Project Name: **HOFFMANTOWN WEST CHURCH**

Martin Chavez, Mayor
Interoffice Memorandum

April 11, 2005

To: Sheran Matson, DRB Chair
CC: Claire Senova
From: Elvira Lopez, Planner
Subject: EPC Project 1002371, 04EPC-01713; DRB Project 1002371, 05DRB-00560

GROUND COVER LEGEND

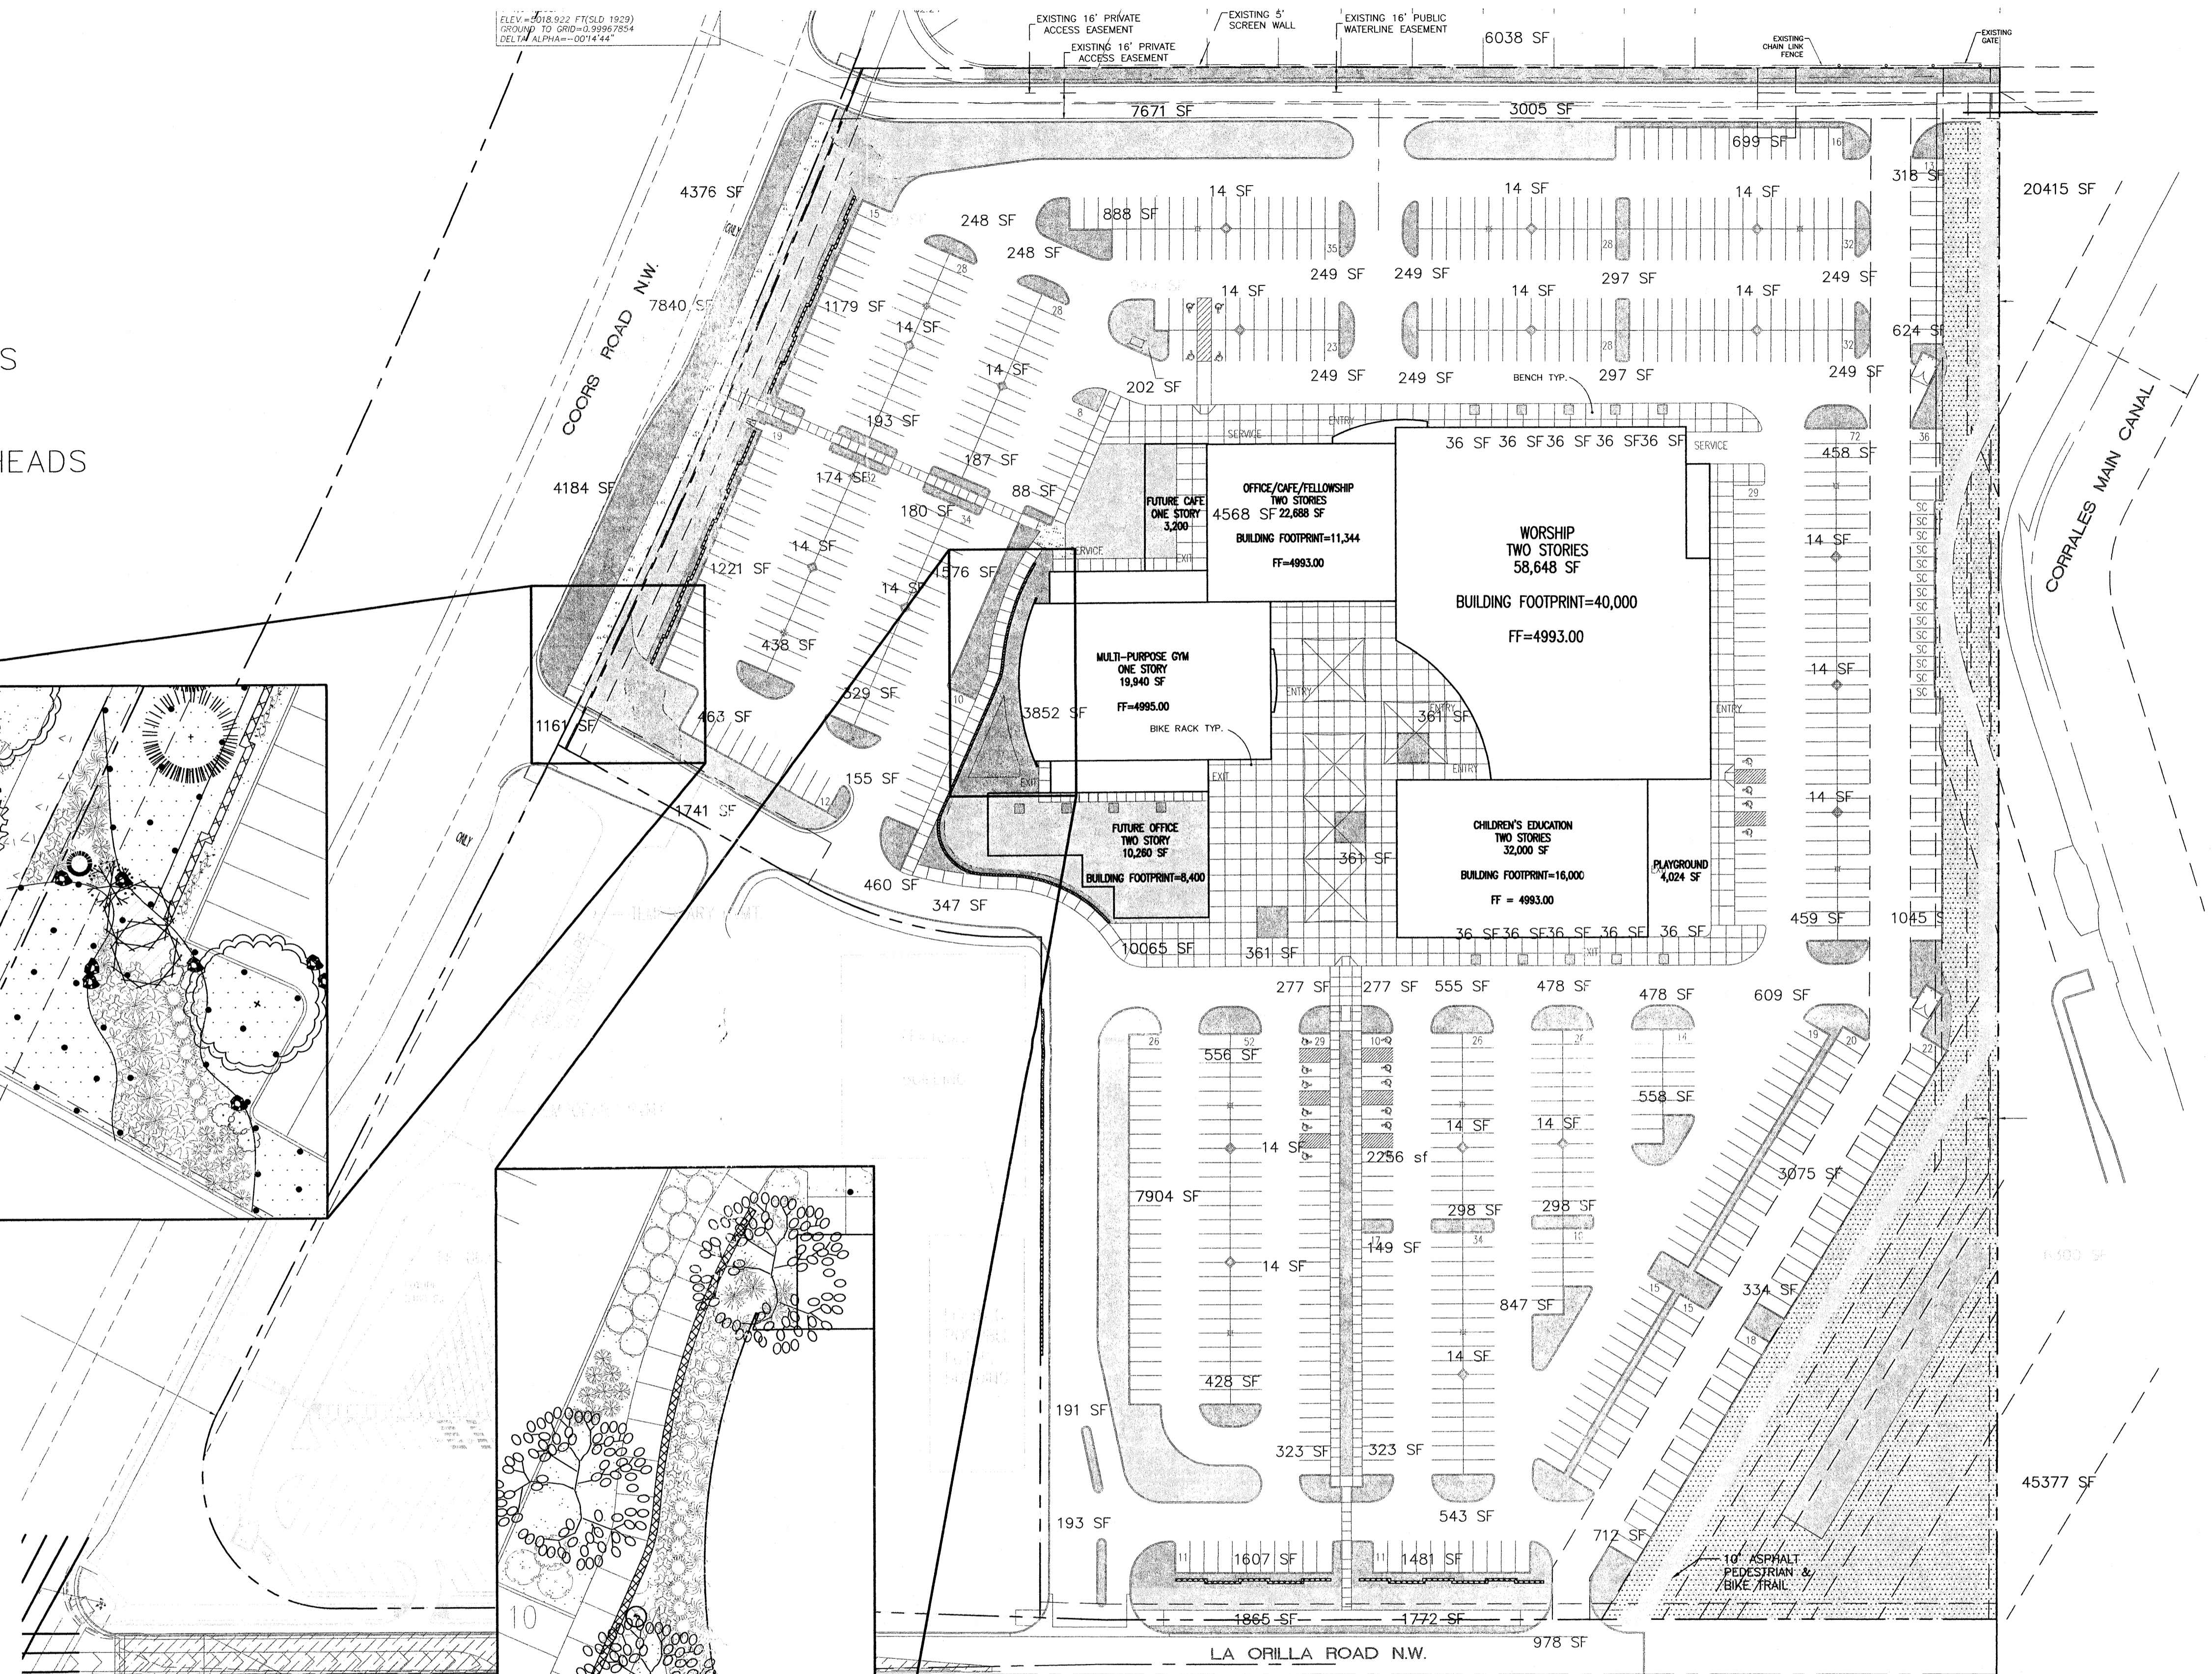
10d. Not met. The plan still contains a symbol in the legend indicating that Santa Fe Brown Gravel with Filter Fabric and Santa Fe Brown crusher fines are being provided in planting beds. These should be removed and replaced with groundcover materials consistent with the Coors Corridor Plan.
